From: Ian Wightman [REDACTED]
Sent: 06 February 2013 17:10
To: Anthony Perry Associates
Cc: Janice Chapman; Martyn White
Subject: RE: Myrtle Cottage, Bognor Regis

DRG. 1793/26A 1:50.

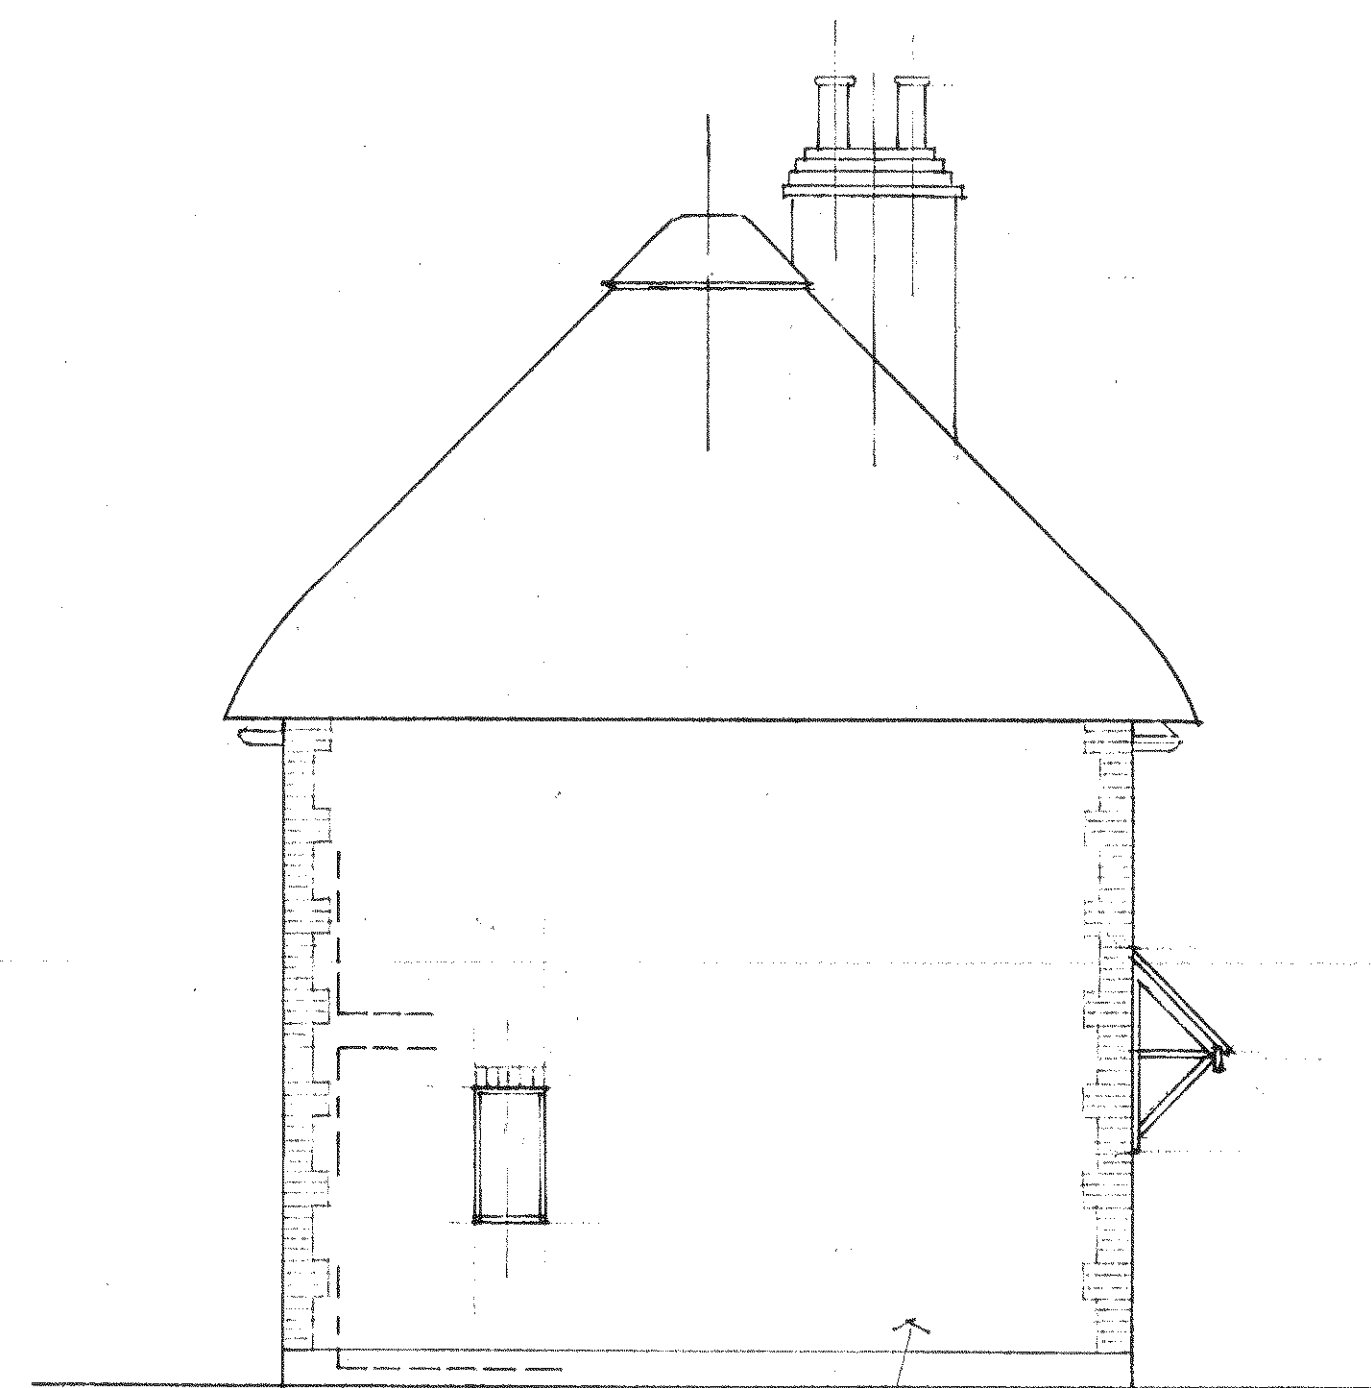
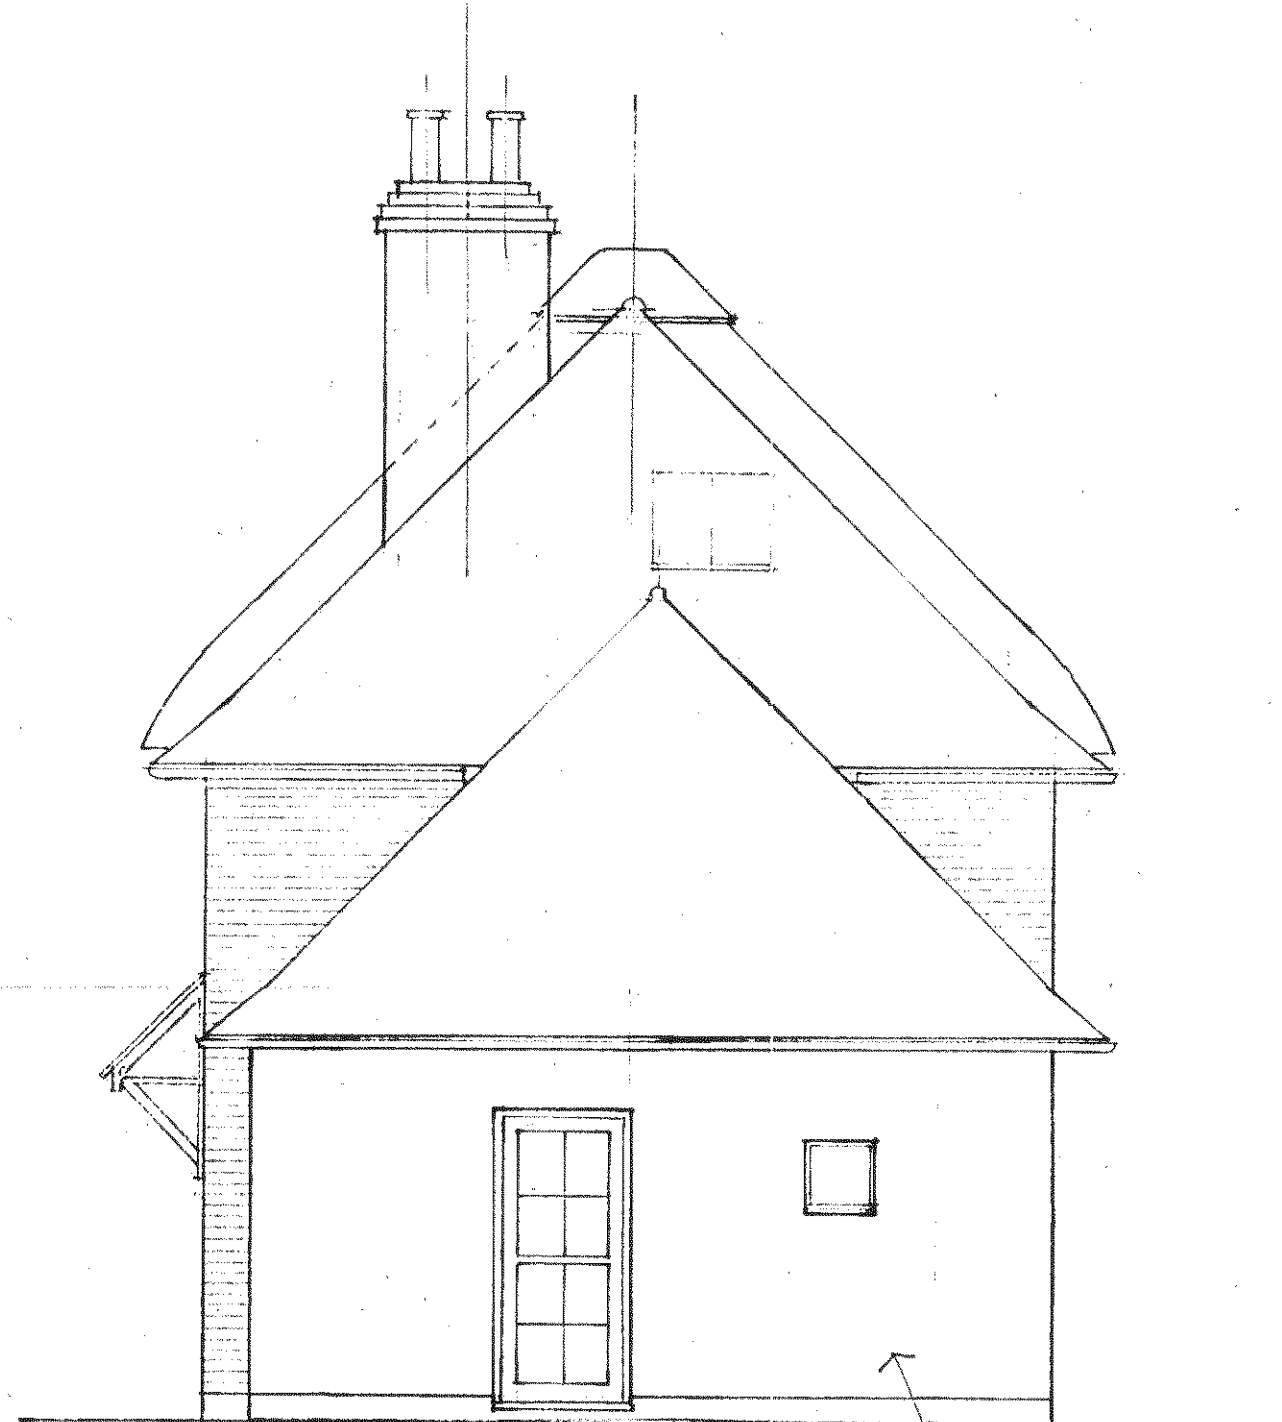
As indicated on the Approved drawings, of course, the openings and windows will have glazing bar arrangements to produce the proportions generally matching the character of existing windows: all as generally agreed. The construction, of course, is to be in painted timber as required.

Do you have any objection to the new windows and doors having double glazing in which thin timber glazing bars (of appropriate section) are included?

Thank you for your emails. I have discussed the matter with Mrs Chapman and Mr White and can confirm that a 'slim' double-glazing system can be used on the extension, subject to detail.
